V1_Storm Water Management Plan (SWMP) COMMENTS - KMM kup Summary

STORMWATER MANAGEMENT PLAN (SWMP)

Fountain Valley School Academic Building

PCD File No. PPR2610

GESC COVER SHEET

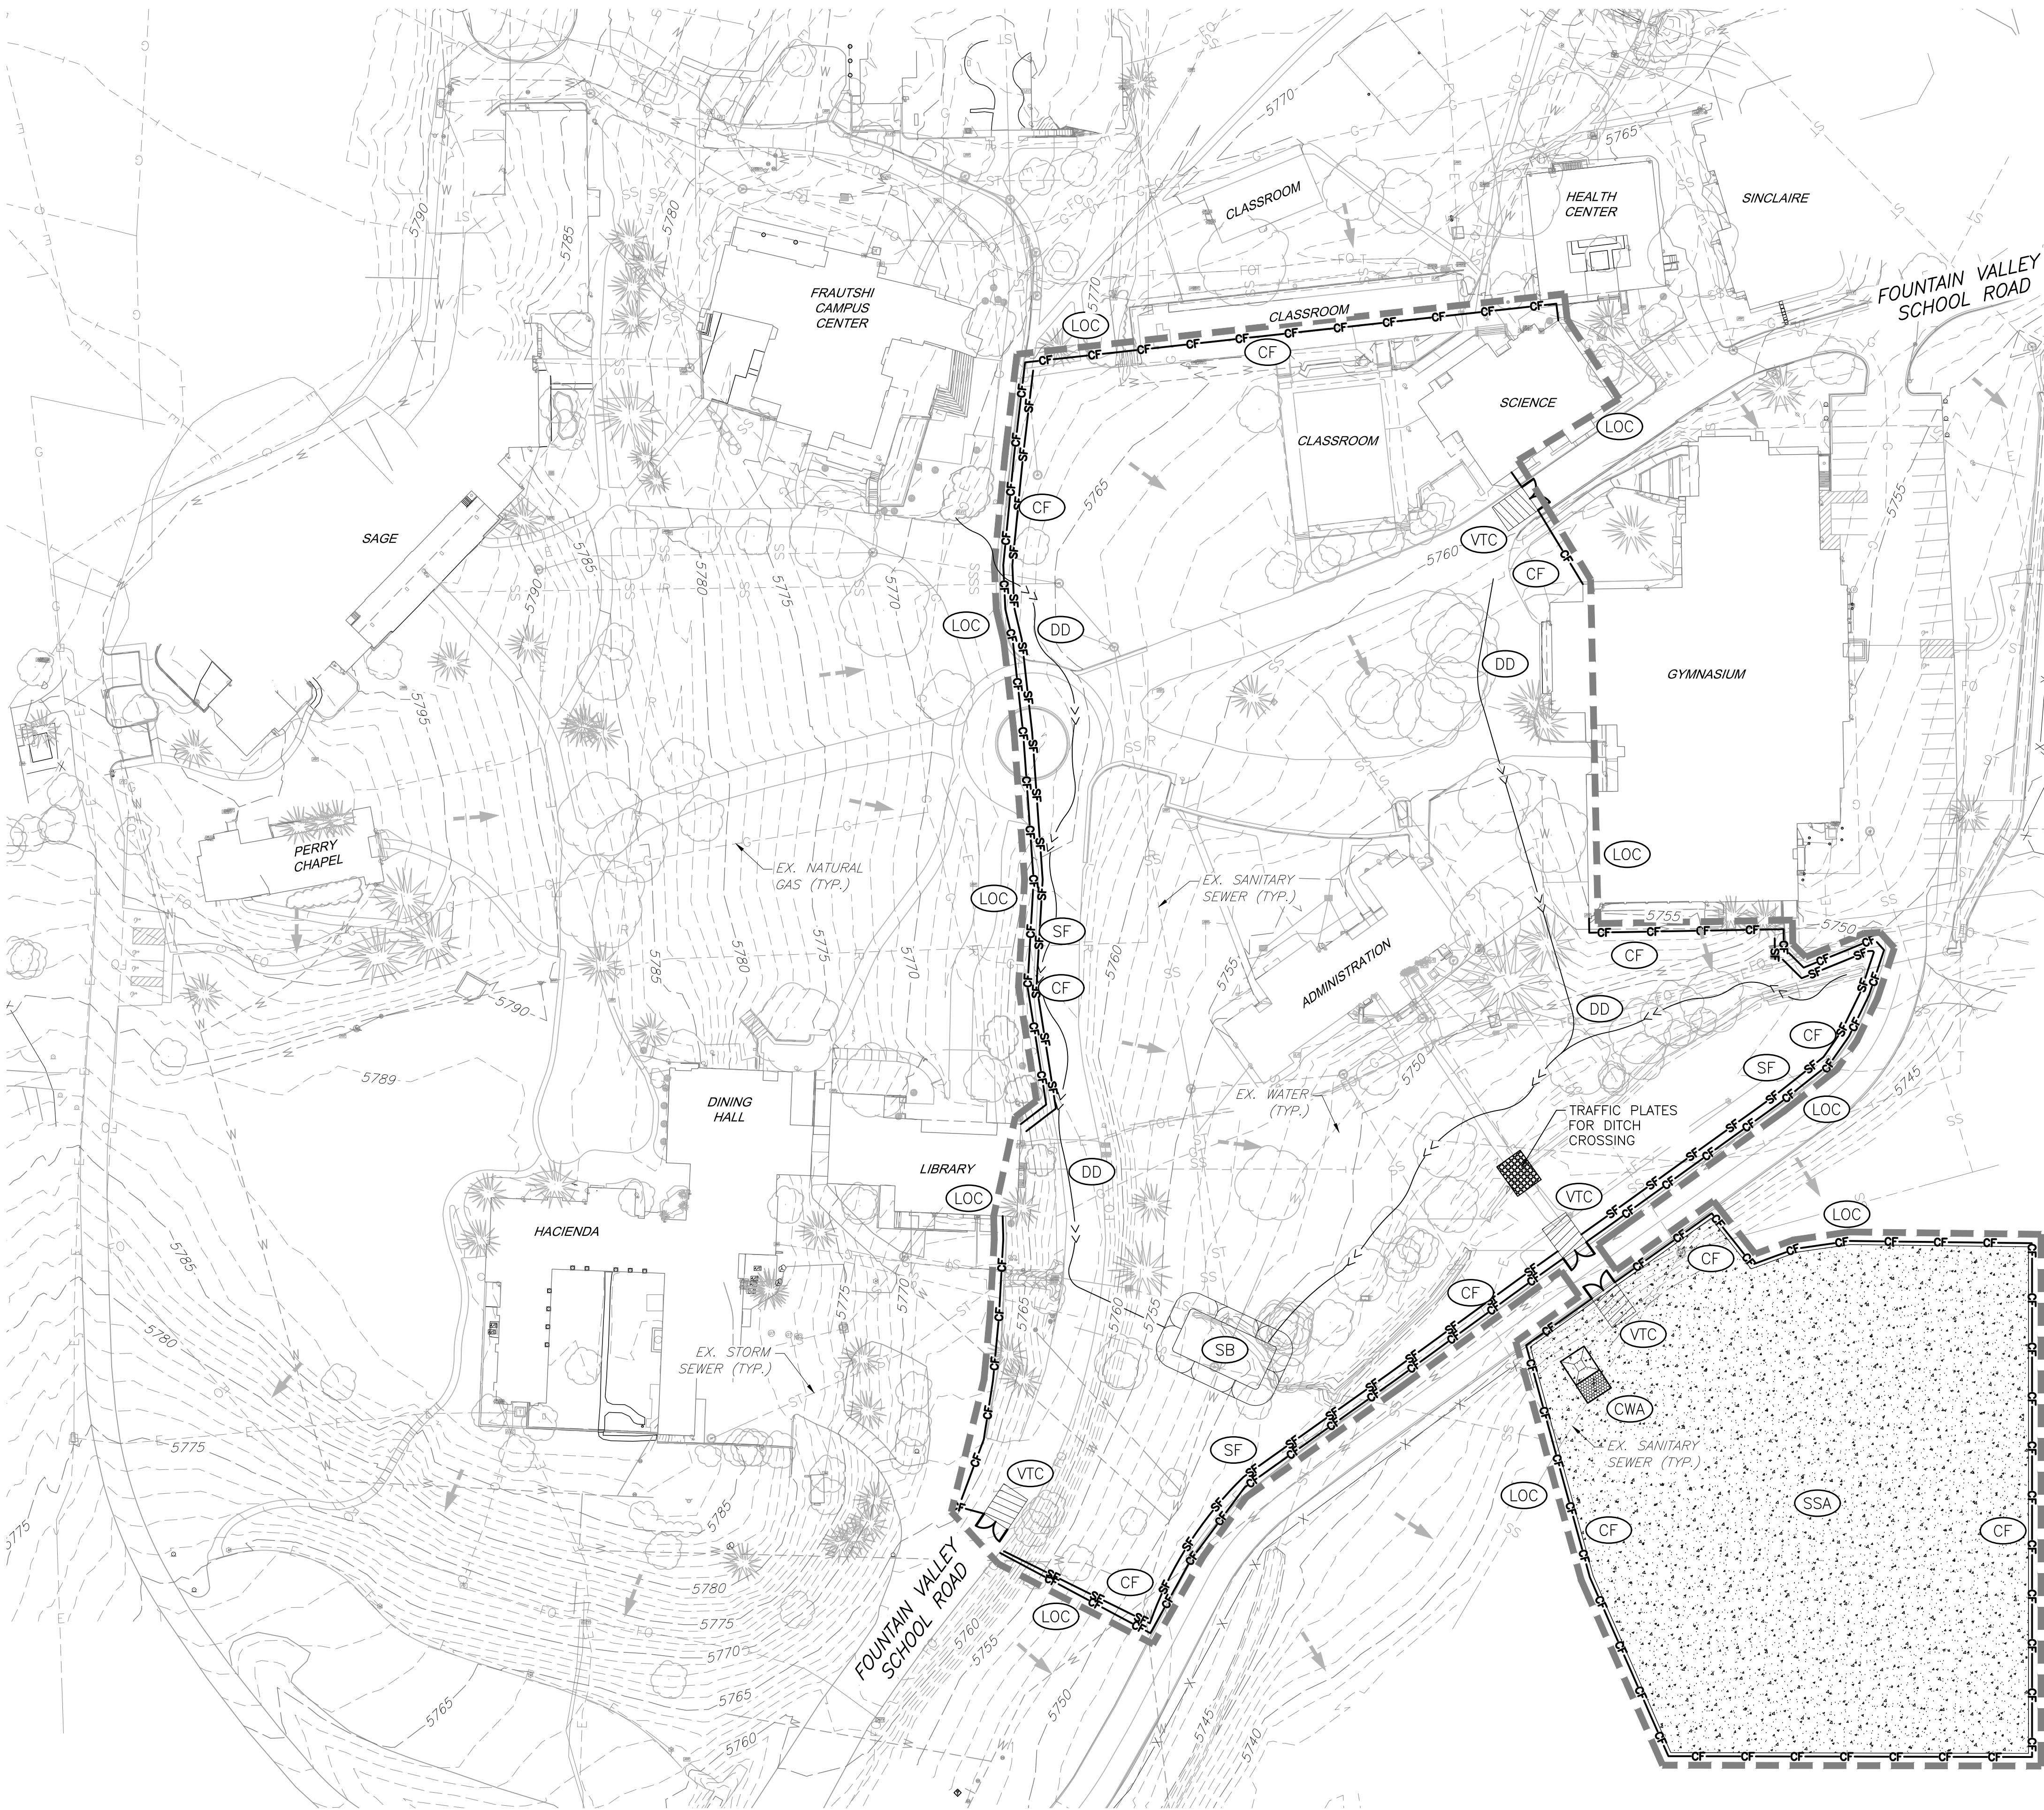
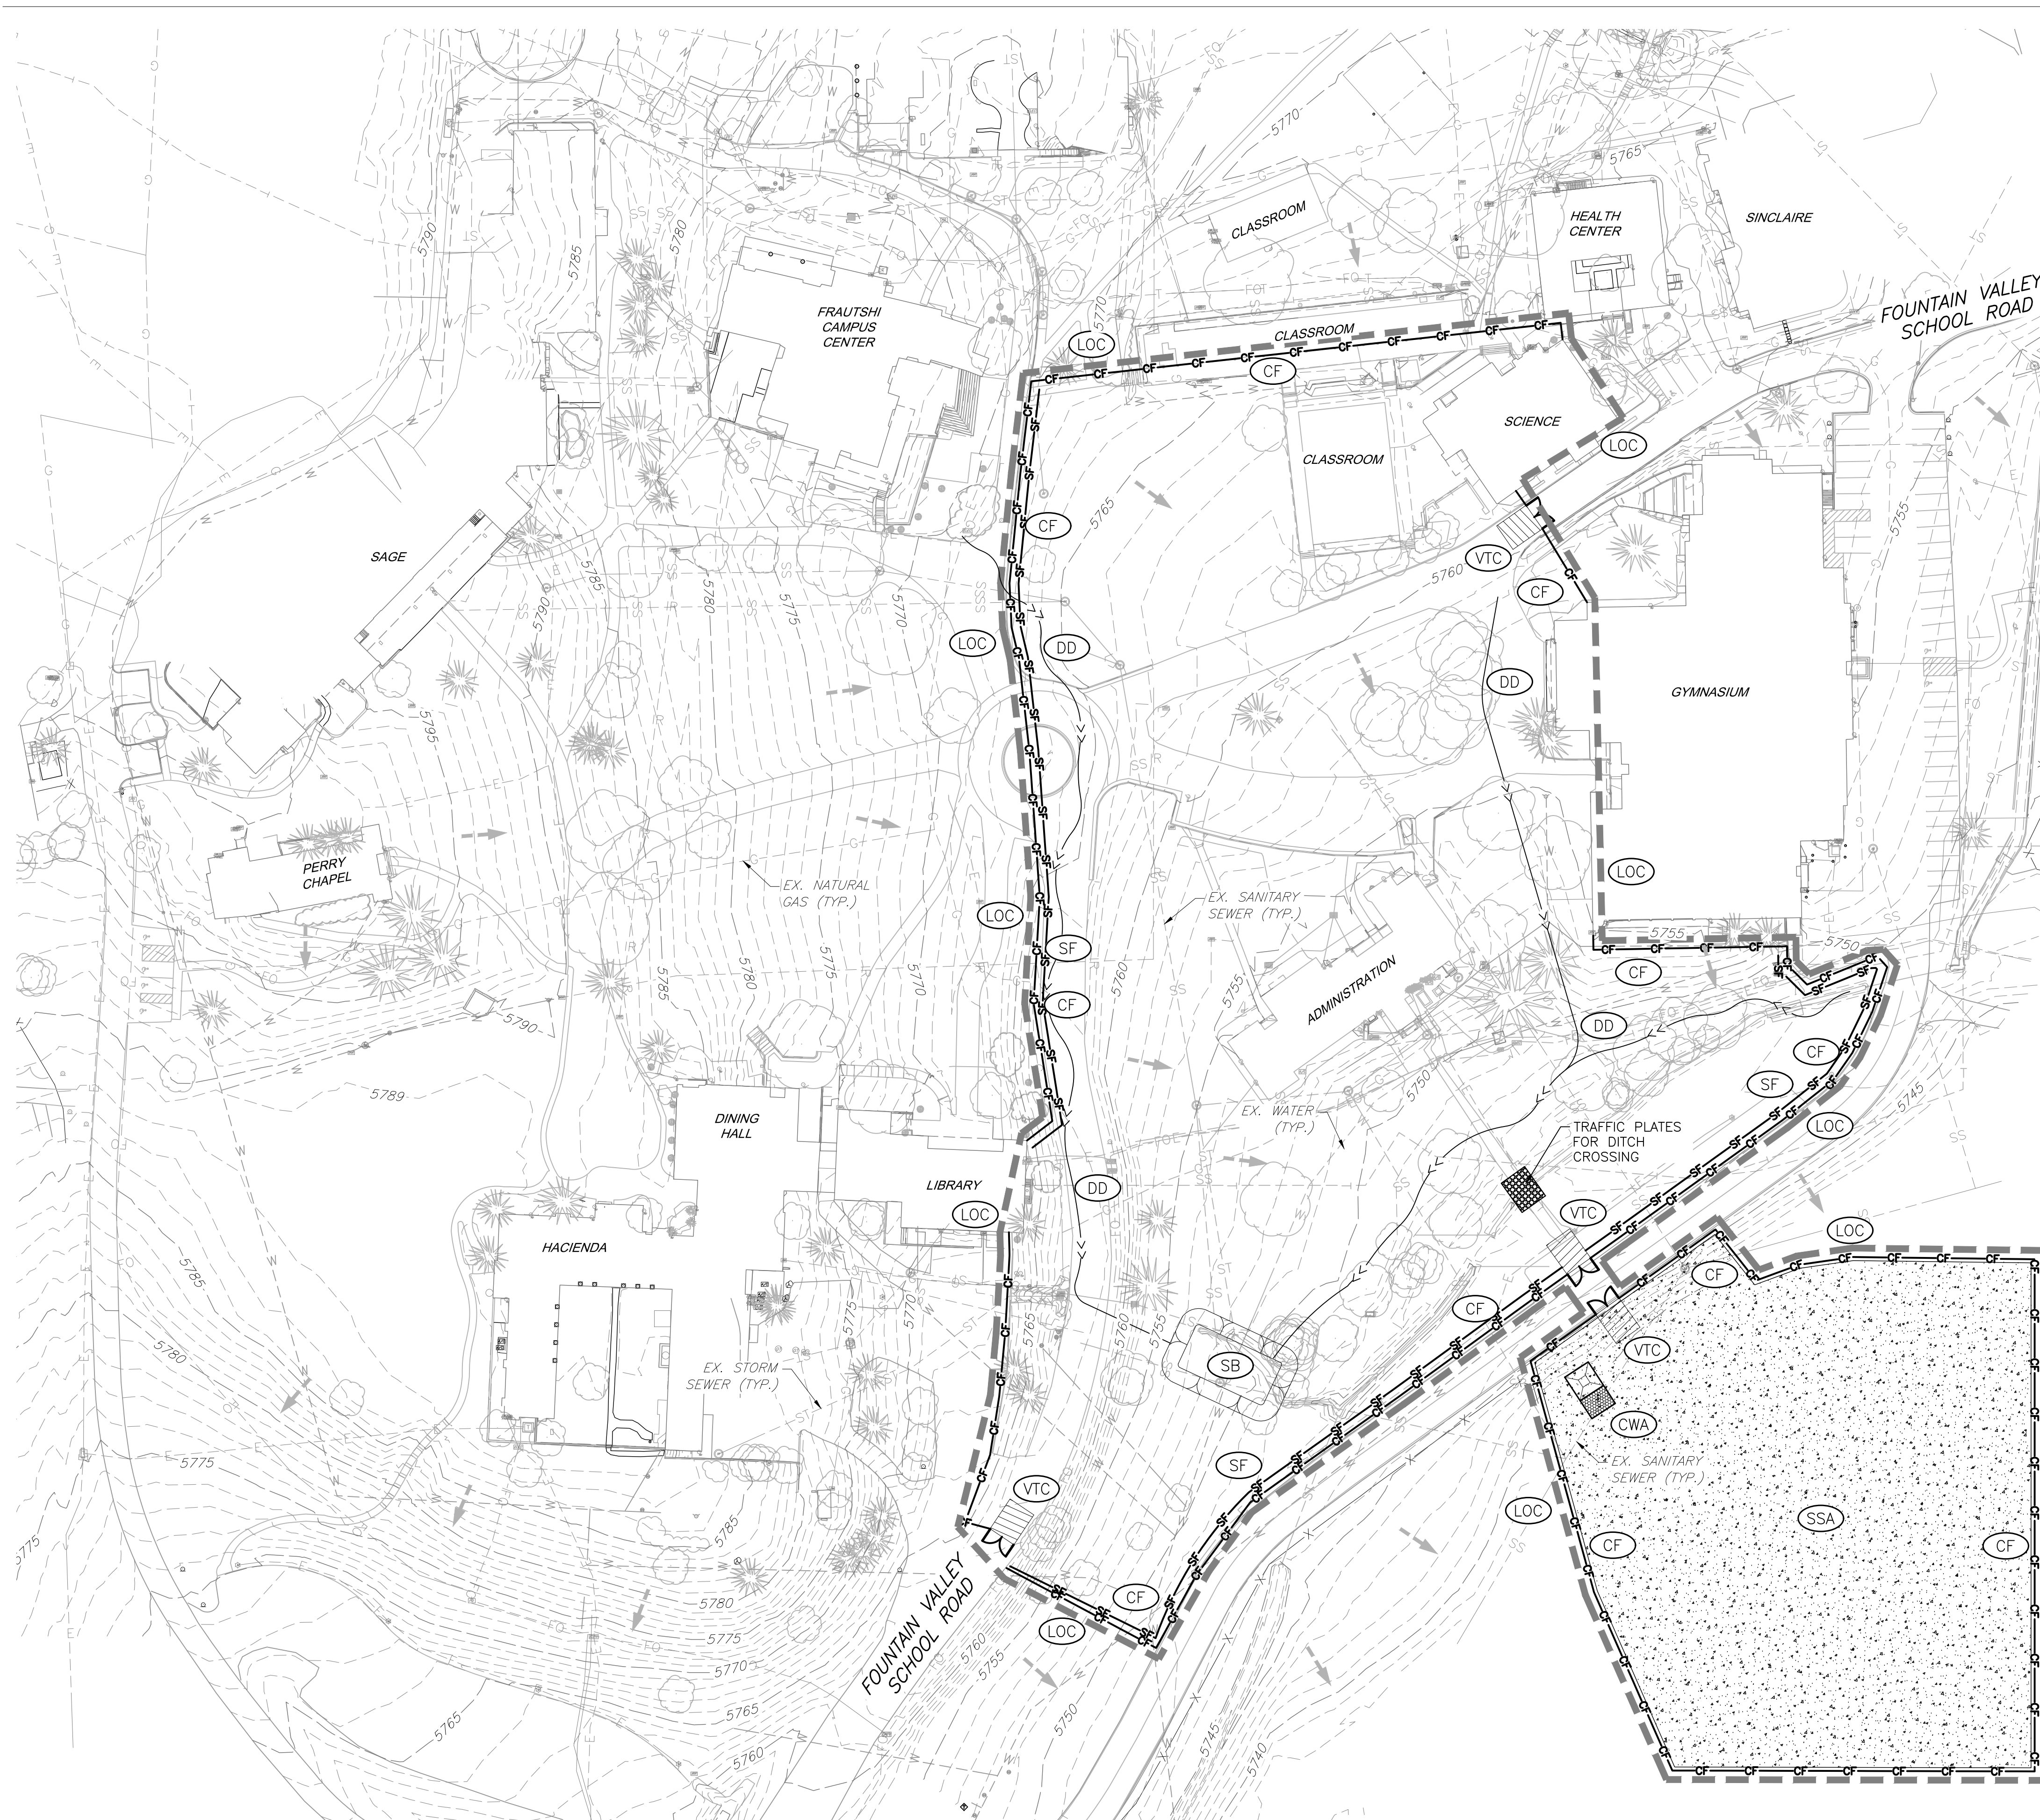
Show anticipated dewatering sites on the GEC plan and provide a dewatering detail. Clarify if the diversions shown on plans are what is being referred to here, or if additional dewatering operations are required.

MM Response:
GEC Plans have been updated with information on anticipated construction dewatering operations per the El Paso County GEC Checklist, item V.

Silt Fence (SF) SC-1

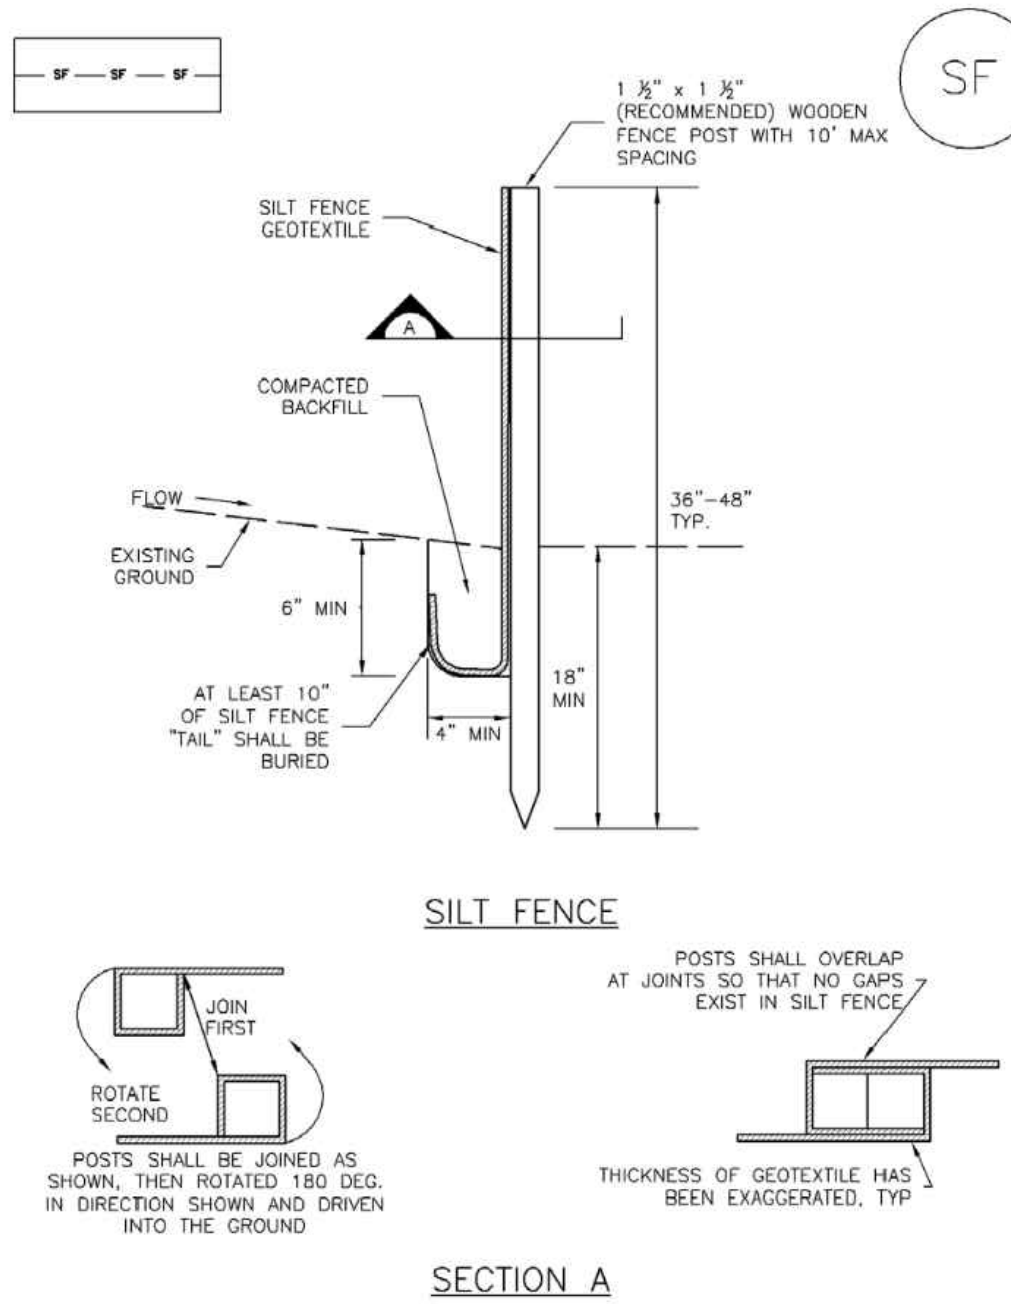
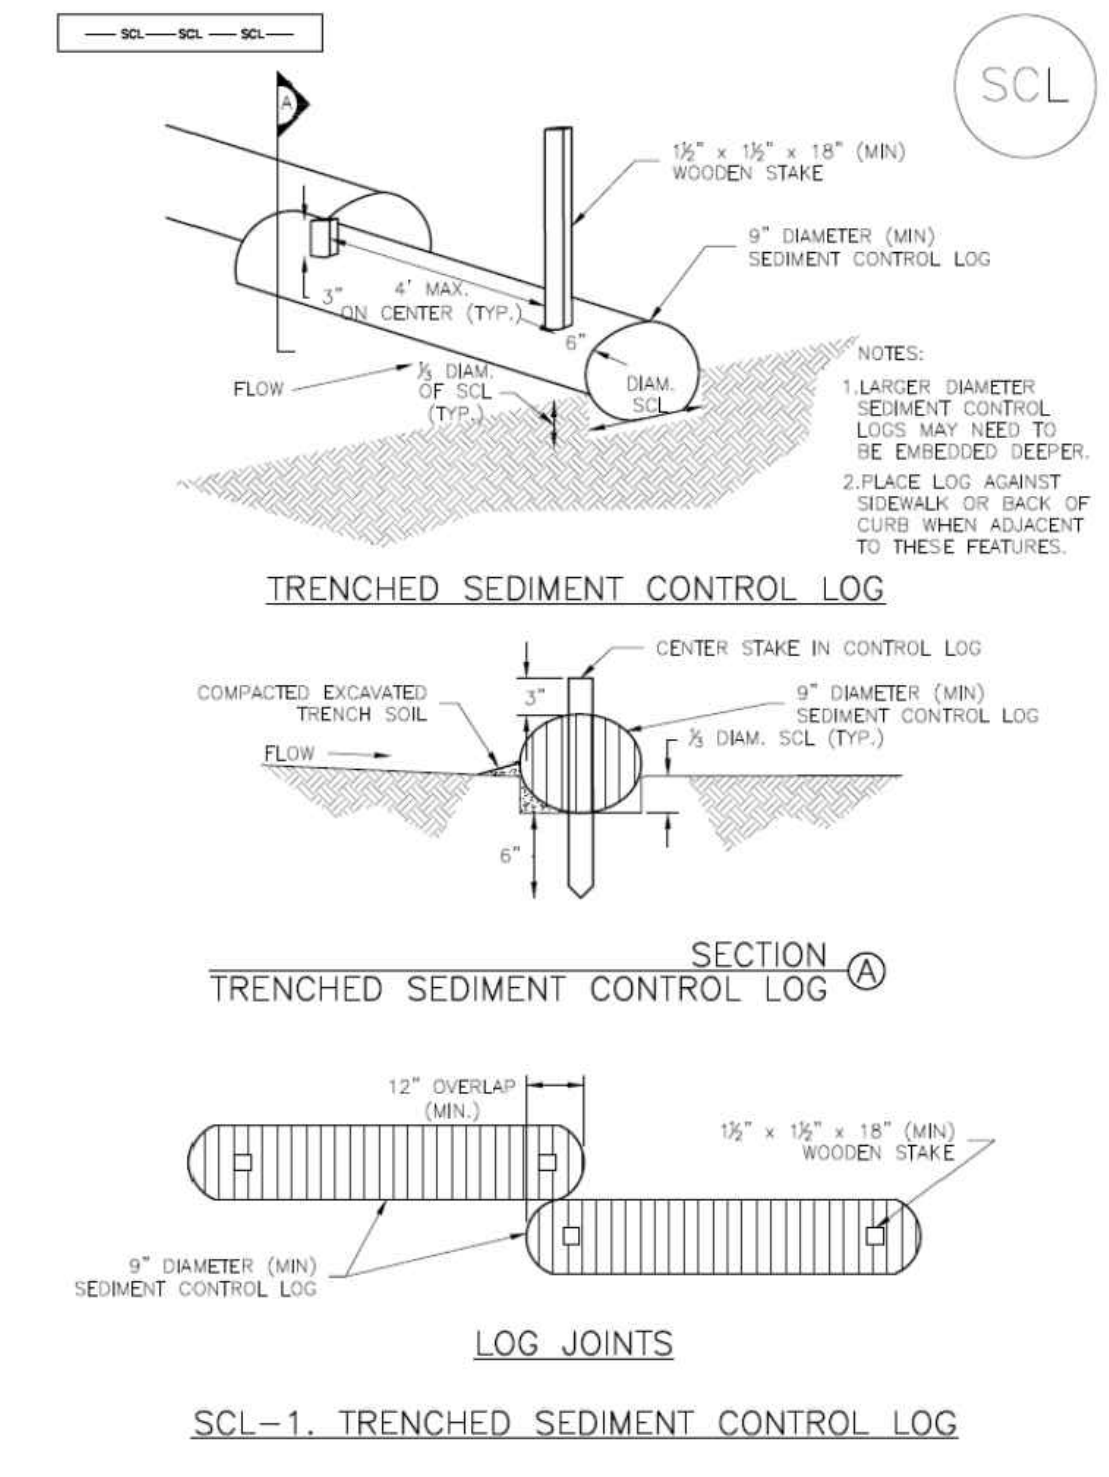
Silt fence is shown in the GEC plan. Please discuss here.
